Article 21 of the Town and Country Planning (General Development Procedure) Order 1995
Application for the approval of details reserved by condition 3 (details of window through the
window opening heads) following a grant of planning permission AW/74/13/
Aldwick Farm Aldwick Road, Bognor Regis,

Arun District Council have decided to **REFUSE details reserved by condition for the following reasons:**

WINDOW SECTION

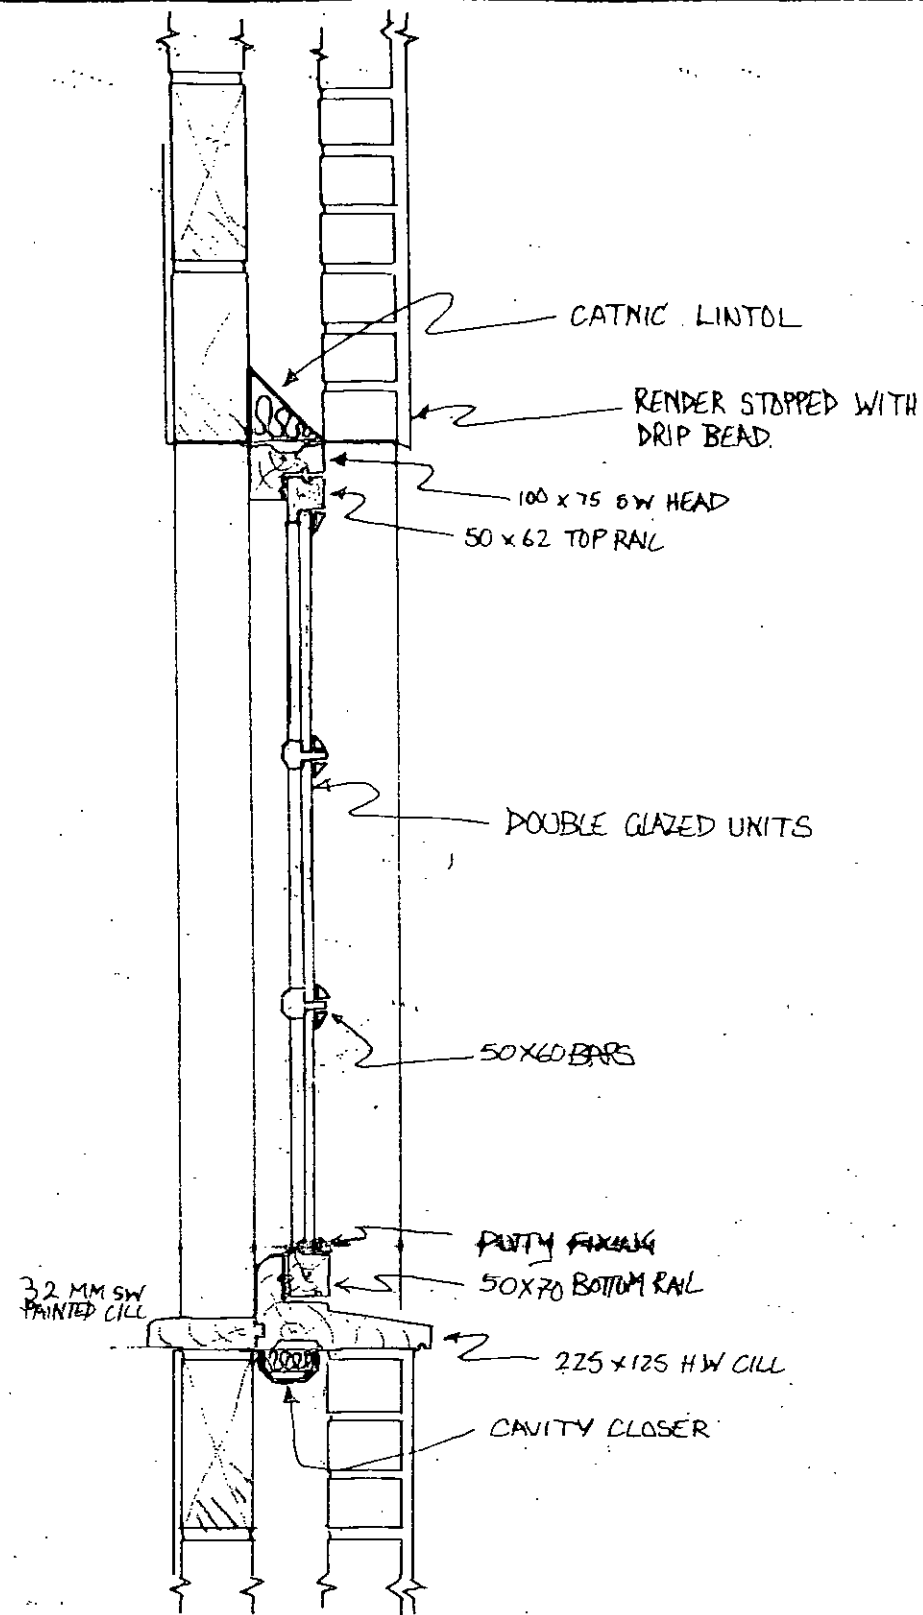
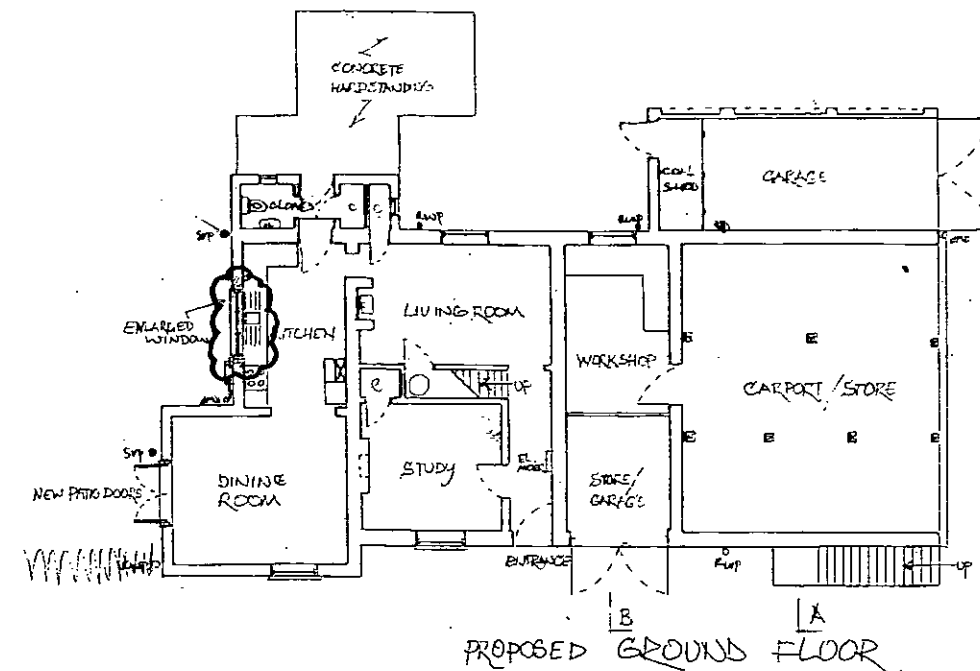
On the grounds that double glazing is proposed, it is not possible to discharge the condition as double glazing is likely to be detrimental to the character of the building and its integrity as an historic structure. If thermal performance is a concern, it is recommended that the window size is retained at its current proportions, or secondary glazing is applied. Please note that submitted details attracted objections from both the Aldwick Parish Council and the Council's Historic Buildings Adviser.

The condition is therefore not discharged and a resubmission of details will need to be made.
